Review of the Noise Conditions – Calga Sand Quarry

Including a review of a Specialist Report and a supplementary report by Wilkinson Murray and supplementary independent review by Renzo Tonin.

1 Background

EXISTING AMBIENT NOISE LEVELS

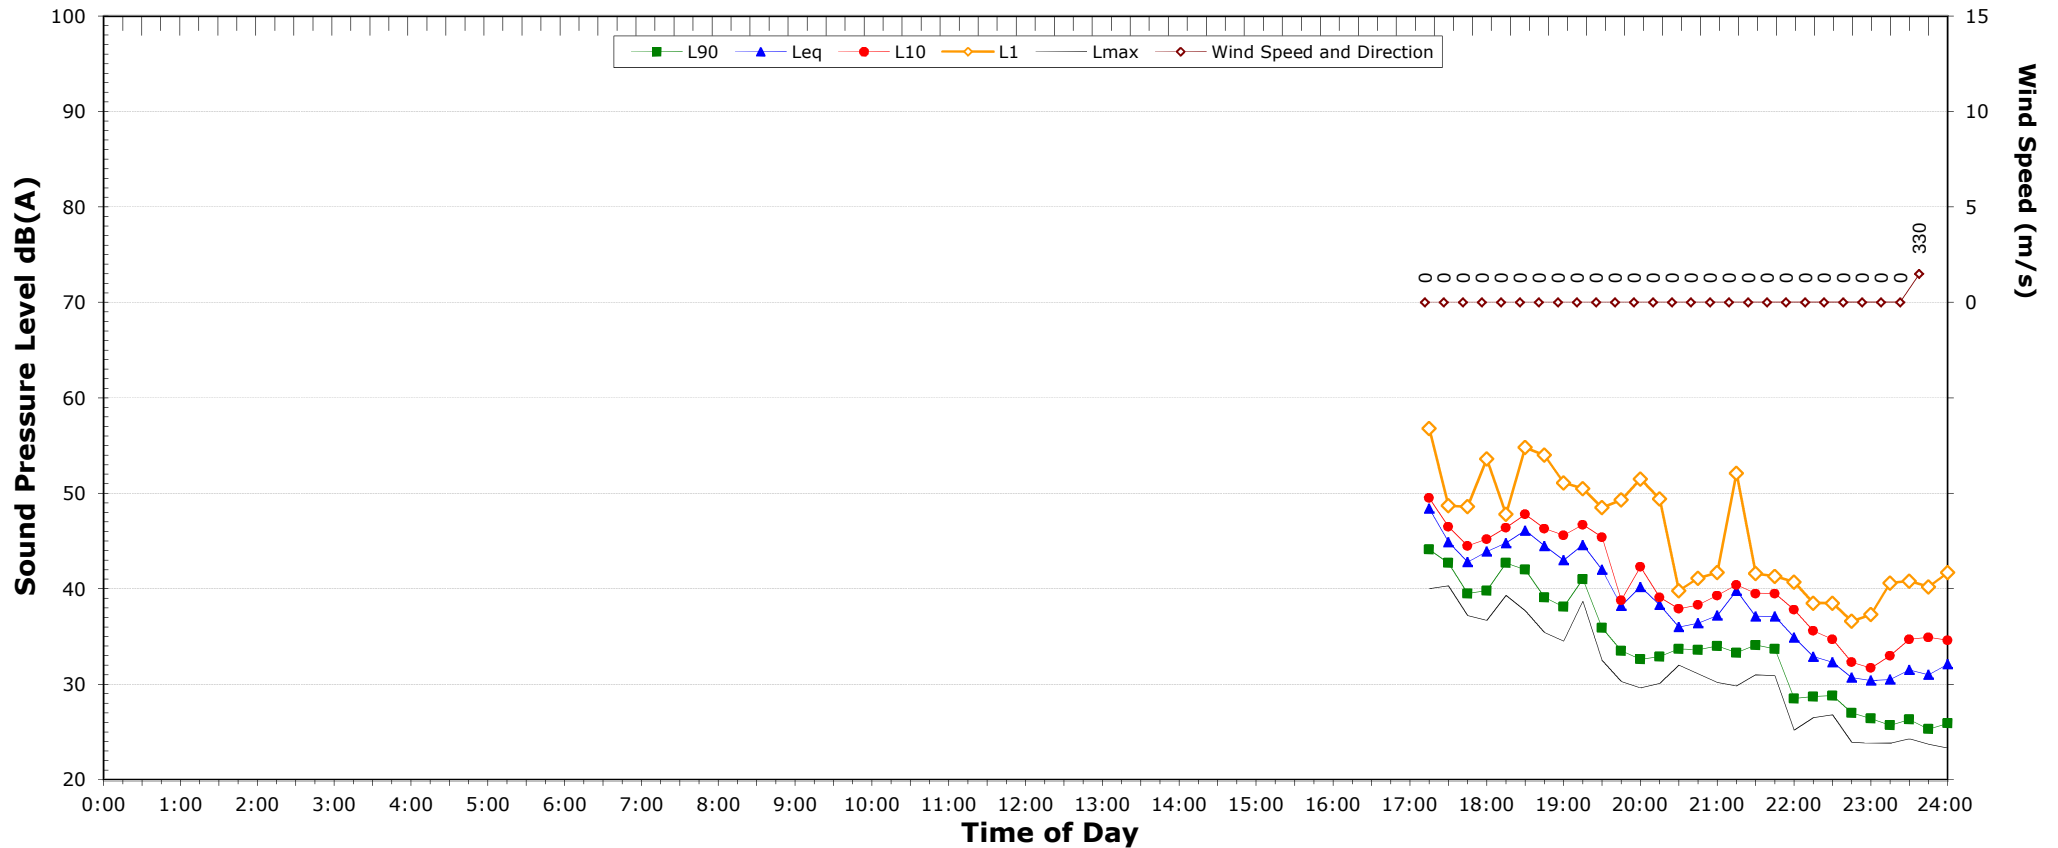
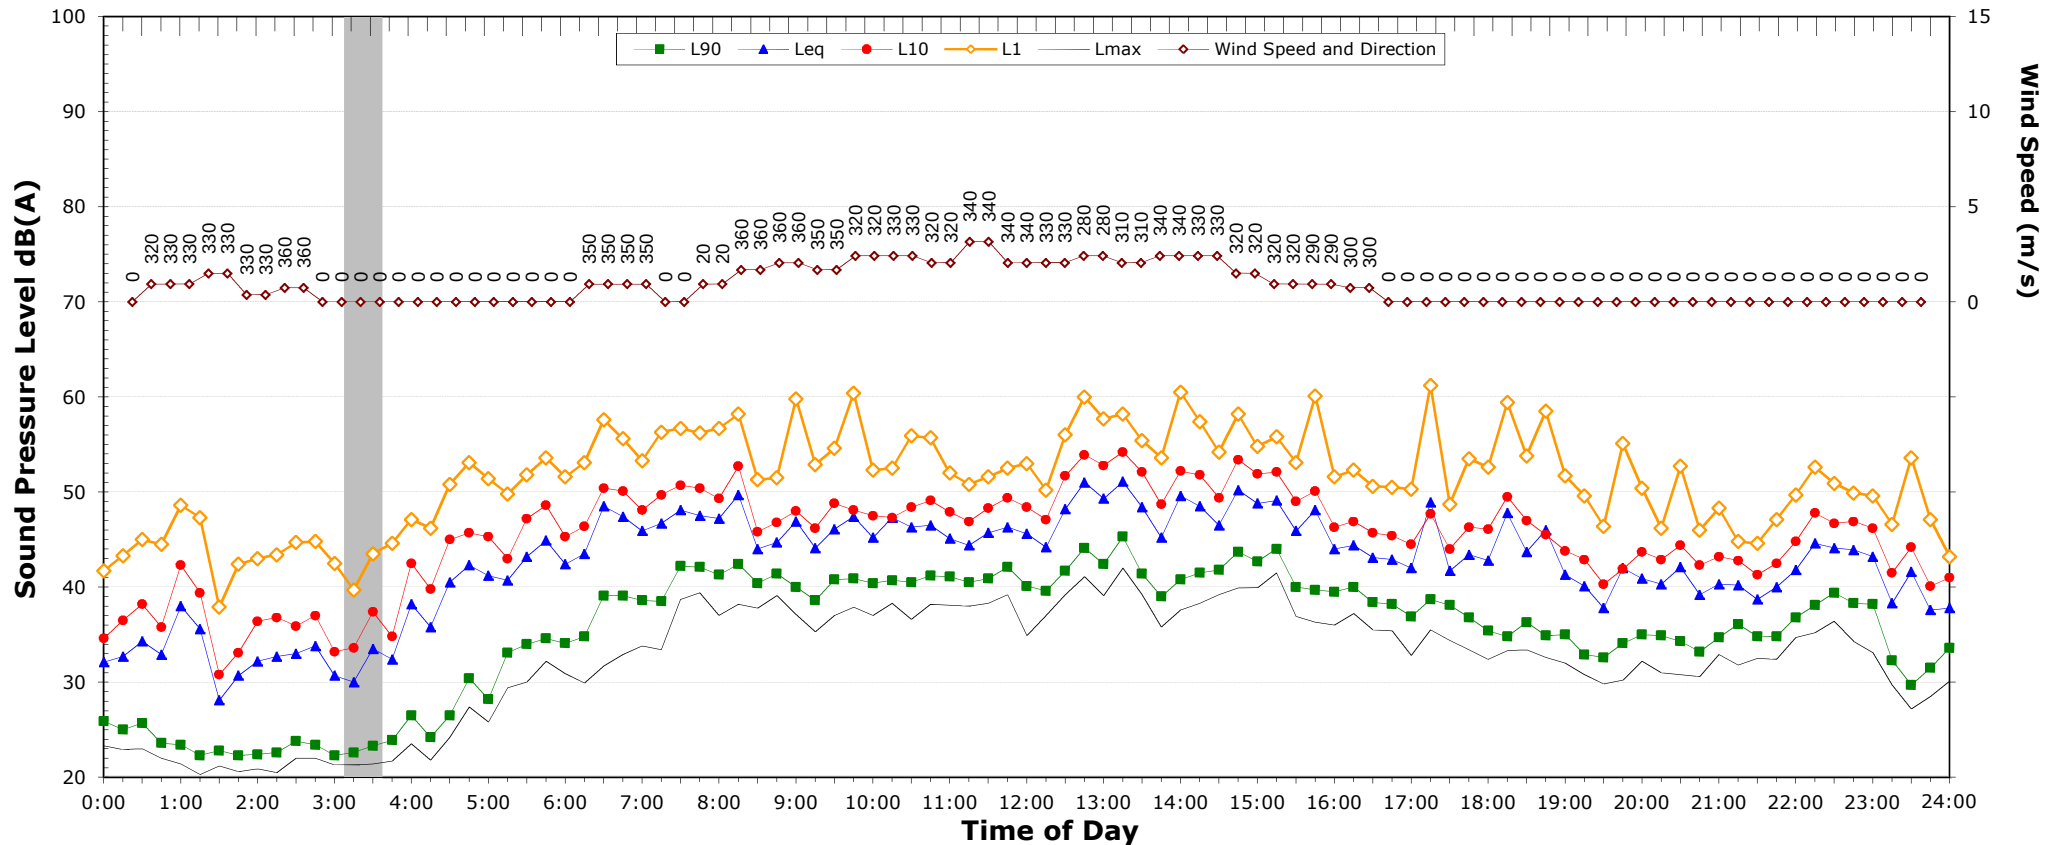
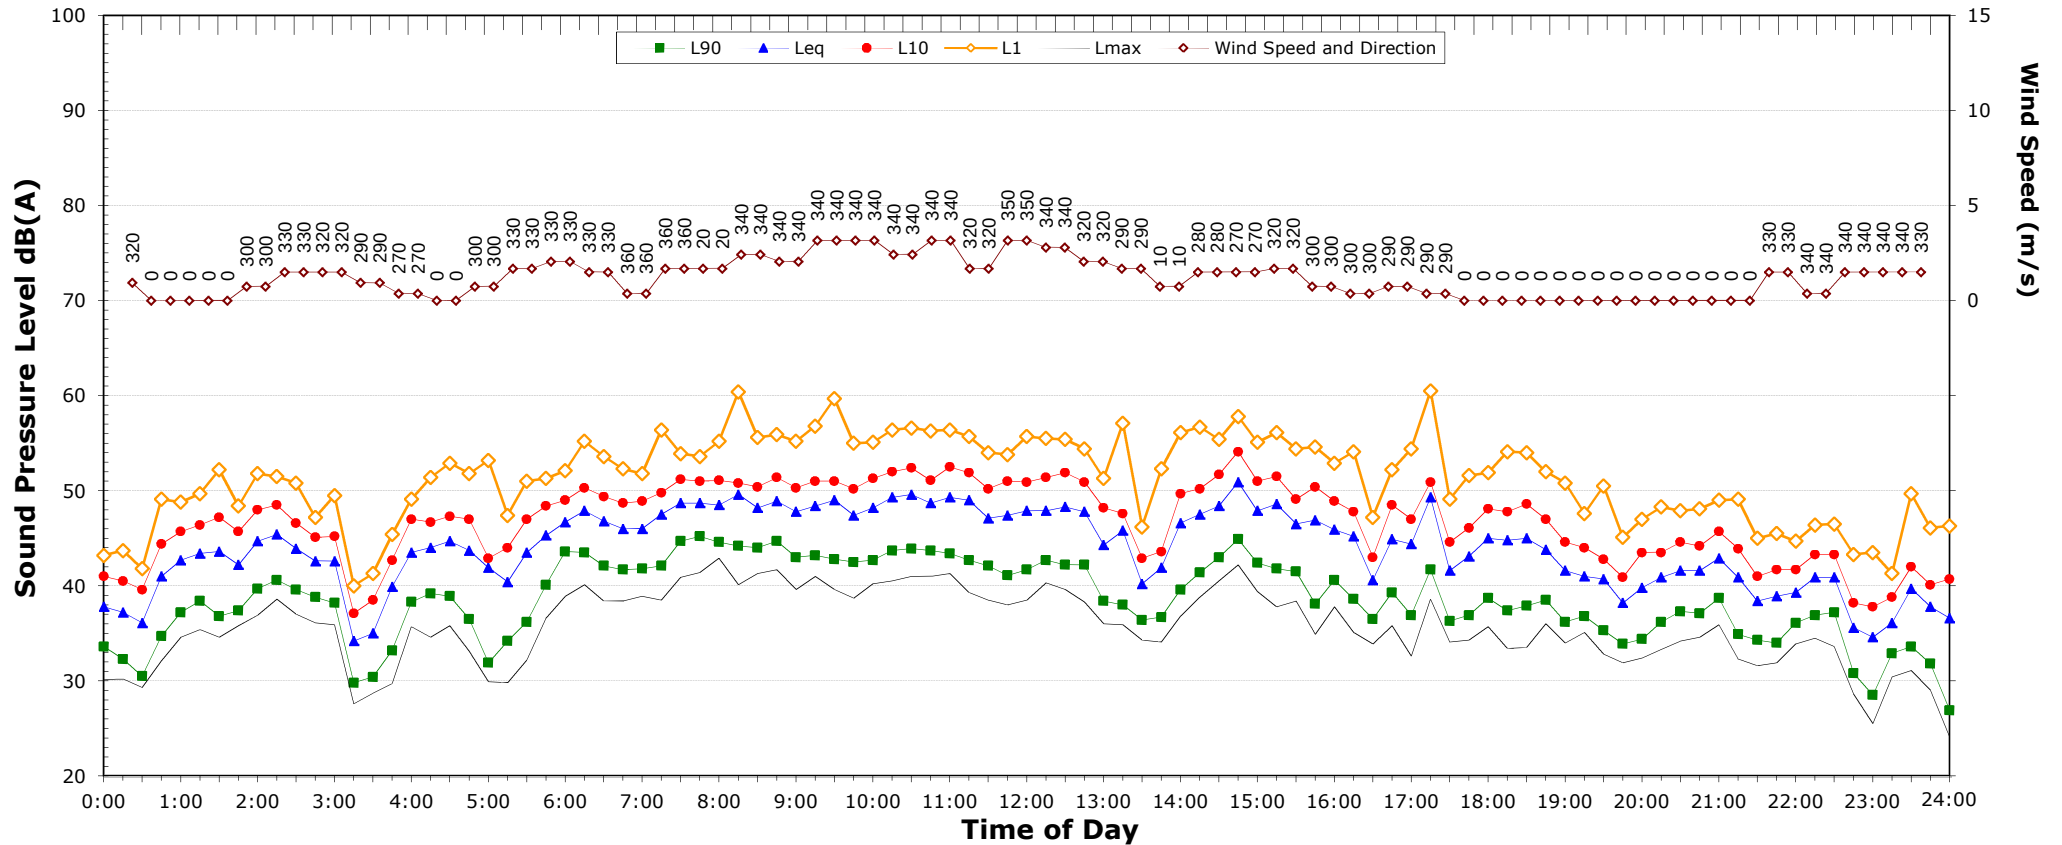
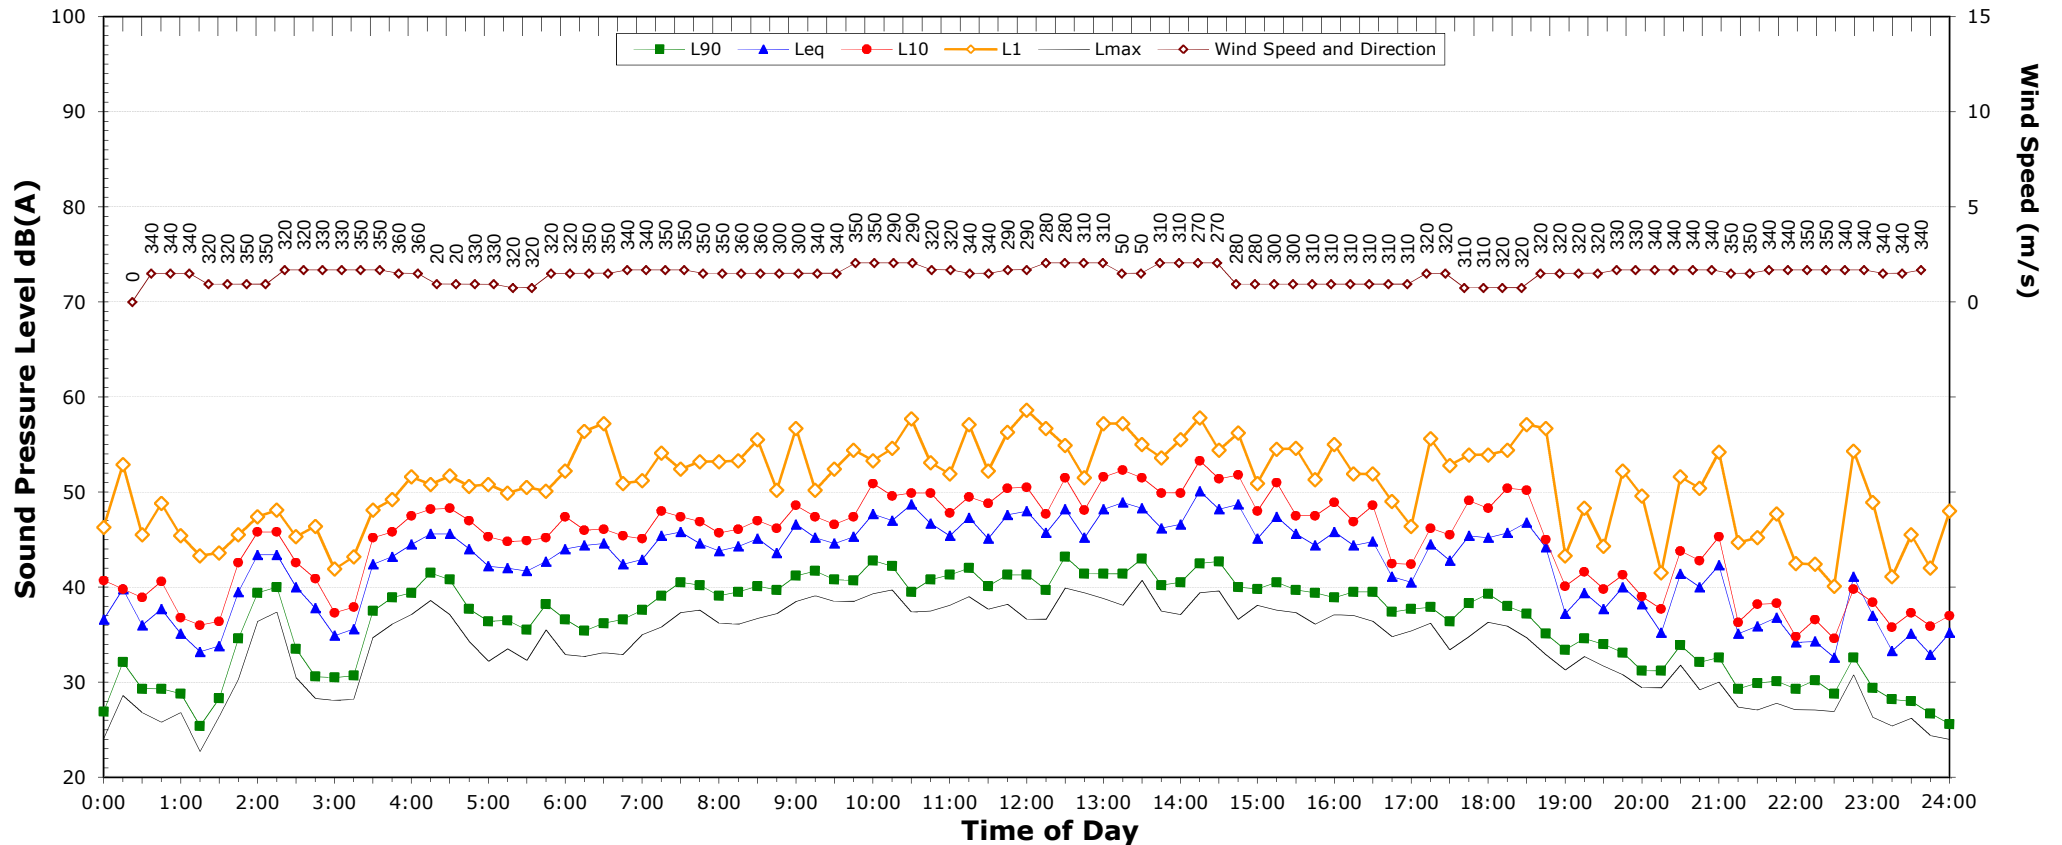
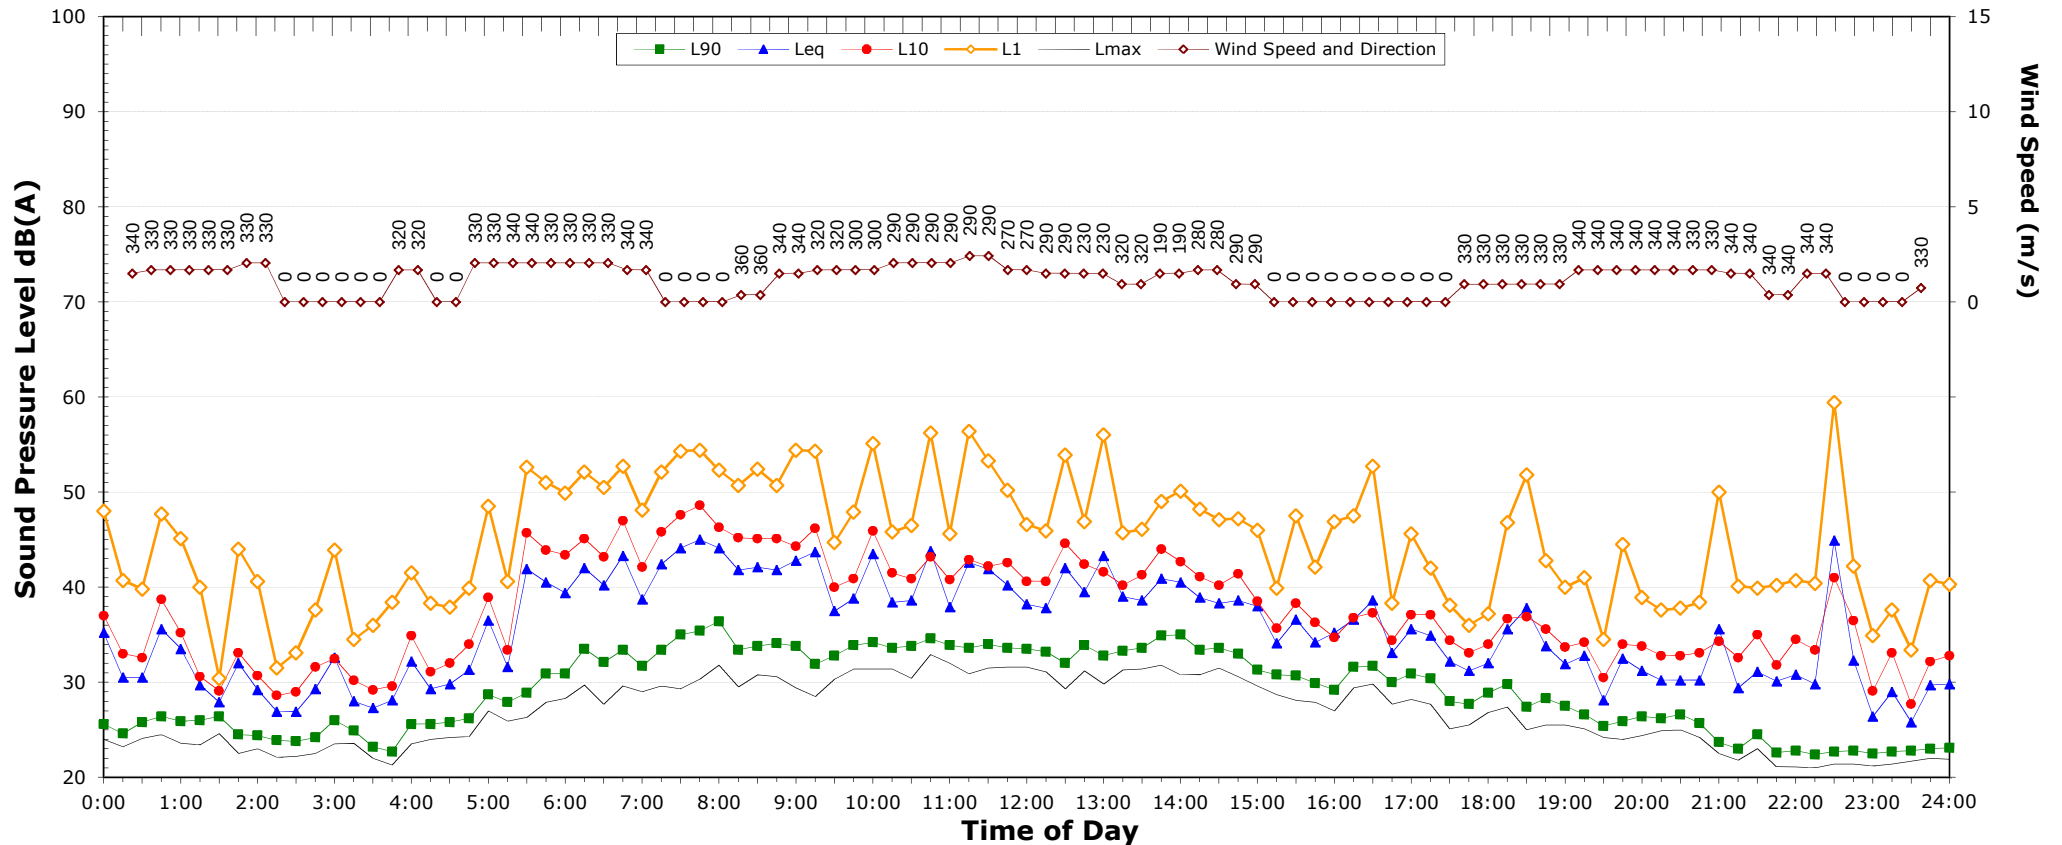
The Renzo Tonin report reports slightly lower background noise levels in its 2013 report, however it is noted that the data was collected under almost continuous northerly winds which are not only non-typical (generally occur less than 5% of the time and would not be considered valid typical monitoring conditions under the Industrial Noise Policy), but also would tend to attenuate road traffic noise, particularly that from the M1 Pacific Motorway. The background noise results contained in the Renzo Tonin report are not consistent with other projects adjacent to the M1 Motorway, which tend to demonstrate that traffic noise underpins the background noise levels throughout the night, and increases significantly from 5am.

Most importantly however, is the collection period only covered 5 mornings including a Sunday on which no work is undertaken, yet was included in the average RBL data set.

Whilst the Renzo Tonin graphs show that the background noise levels recorded during 'working mornings' range from around Leq(15 min) of 30 dB(A) to over 40 dB(A) with an average of around 37 dB(A), the morning shoulder is only a two hour period making it statistically difficult to determine a representative RBL even if a typical range of meteorological conditions are experienced.

The data in the Renzo Tonin report is suitable for assessing the noise impact of the quarry under worst case scenario, however because of the non-typical meteorological conditions and the limited duration of monitoring, it is not suitable for use in determining a RBL. Only the Wilkinson Murray data is considered suitable for the purpose of determining an RBL.
